Our Ref: EN070007

Date: 31 October 2022

Application by Liverpool Bay CCS Limited for an Order Granting Development Consent for the HyNet Carbon Dioxide Pipeline

Advice following issue of decision to accept the application for examination

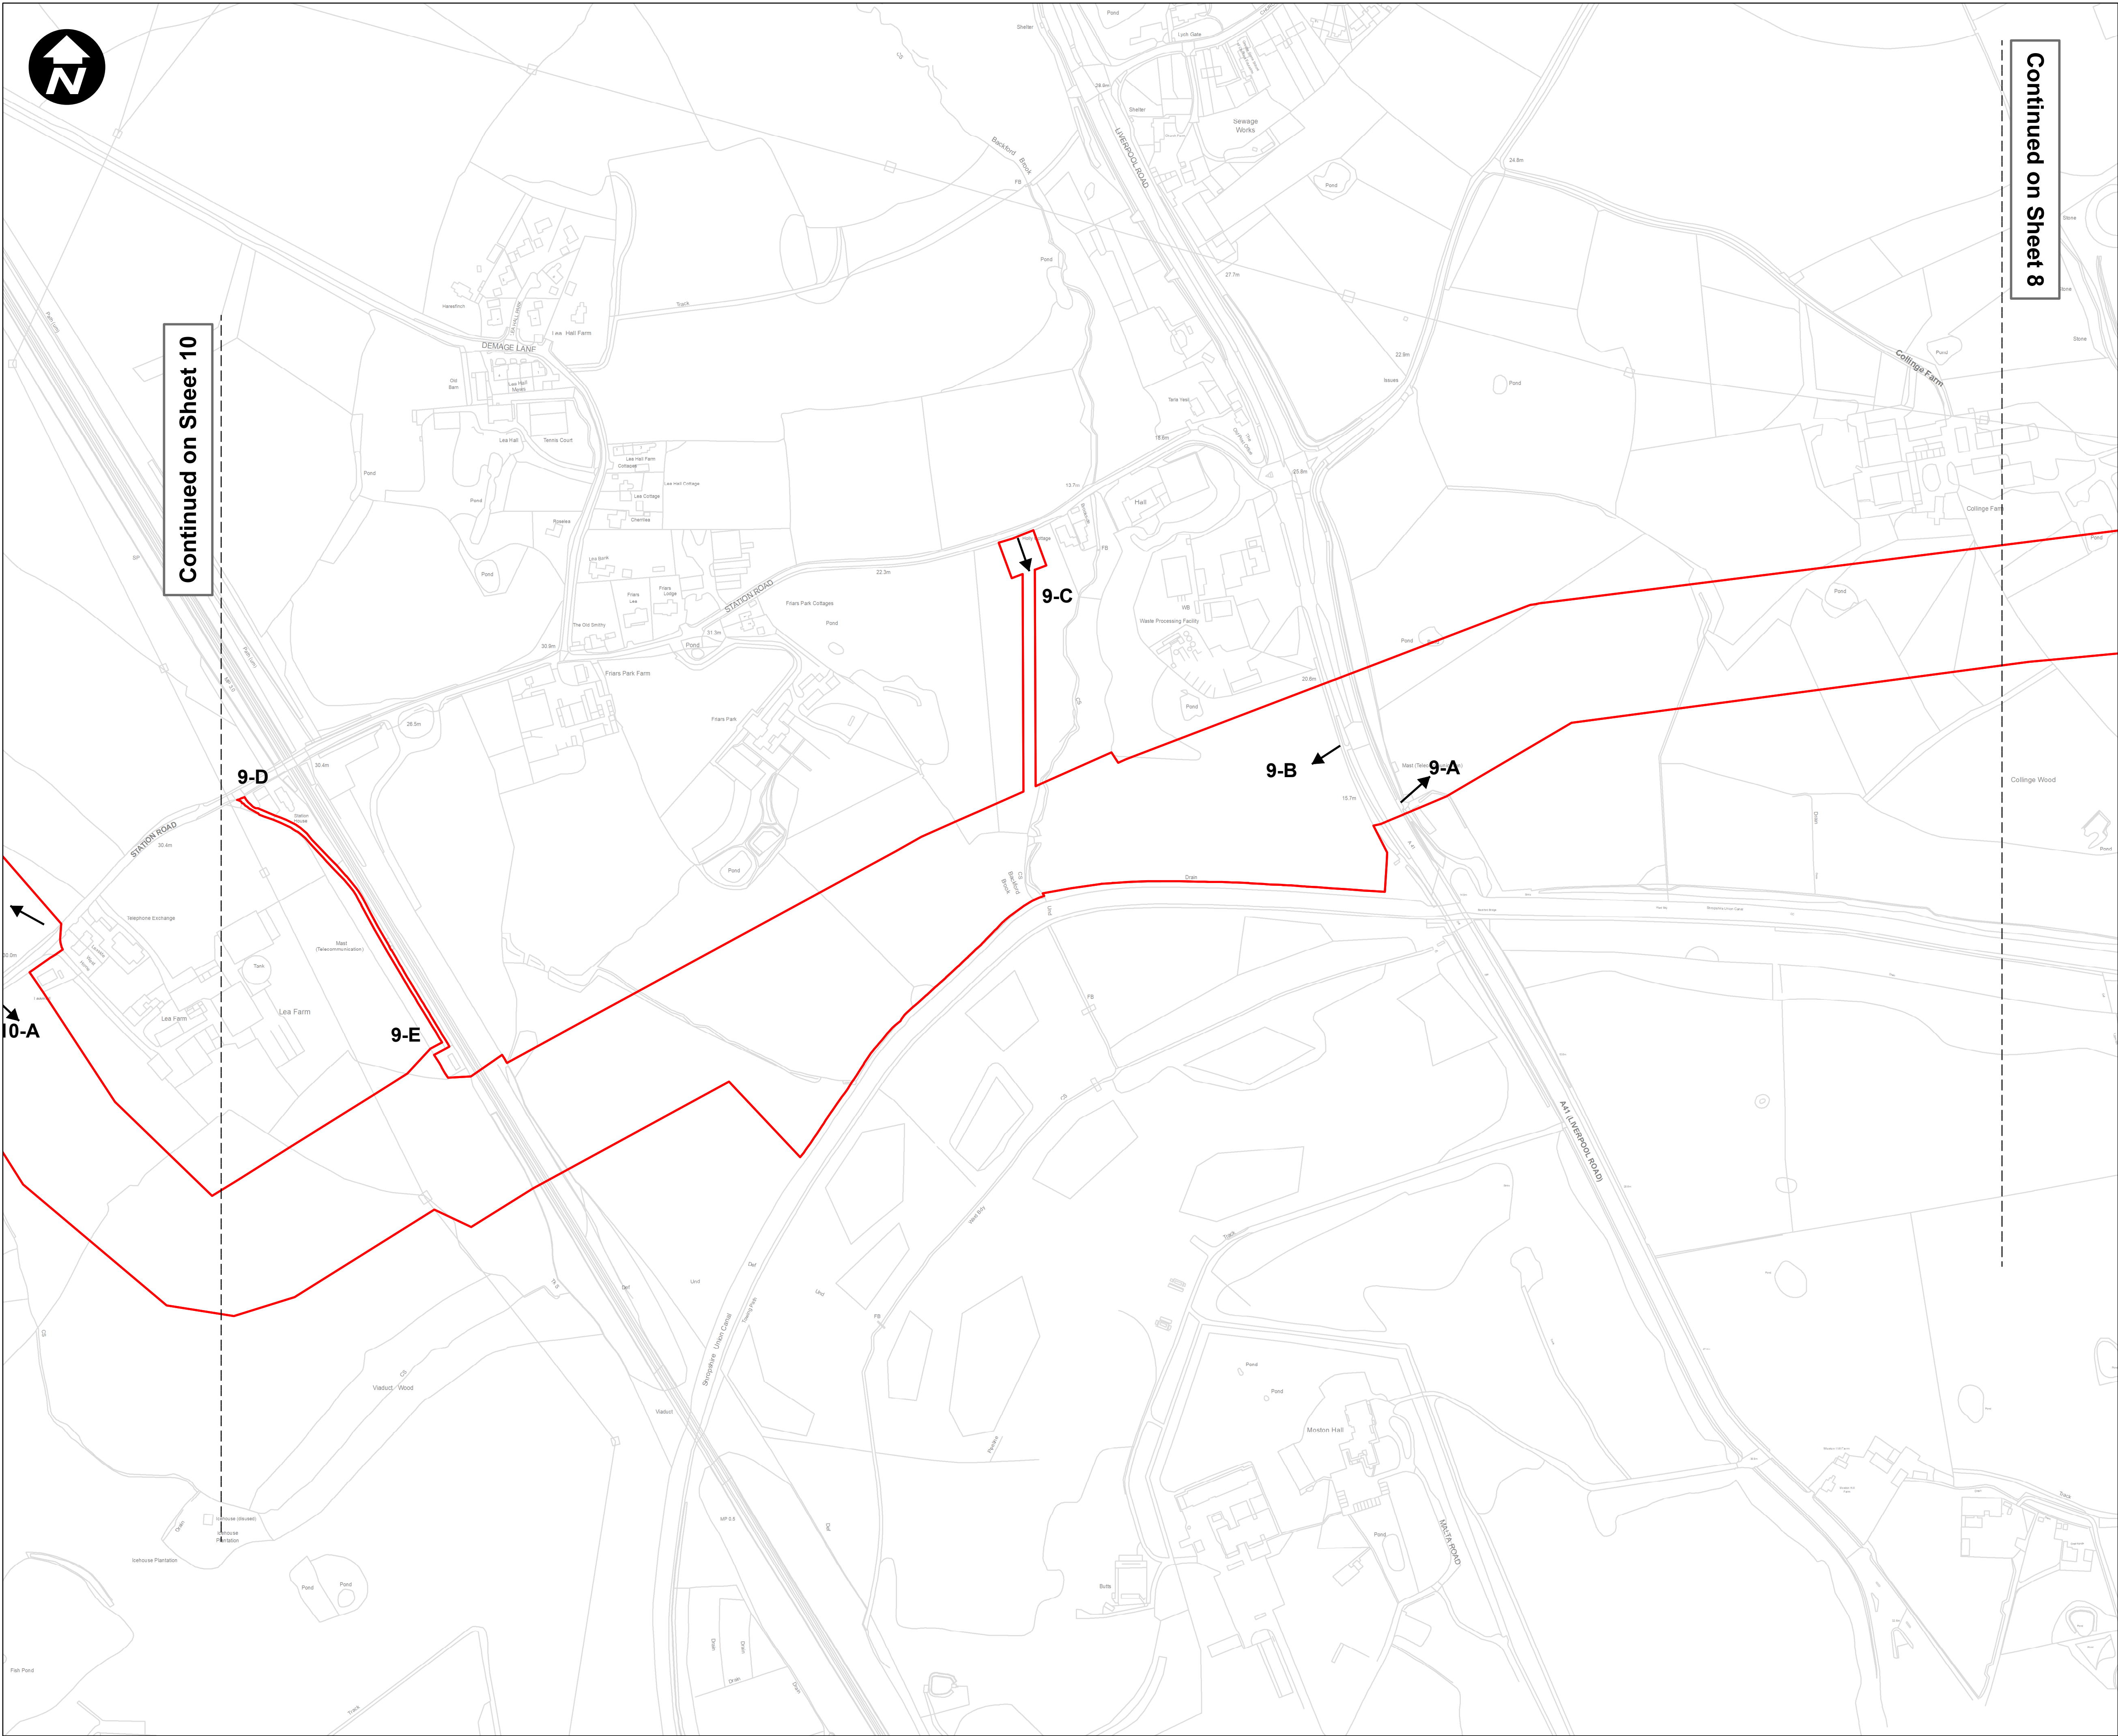
The Inspectorate notes that there are some discrepancies between the draft Development Consent order and the Access and Rights of Way Plans (see Ledger on sheet 8 and footpath 308/1 on sheet 15 of the Access and Rights of Way Plan).

The Applicant is advised to carry out a comprehensive review of the plans against the draft Development Consent Order.
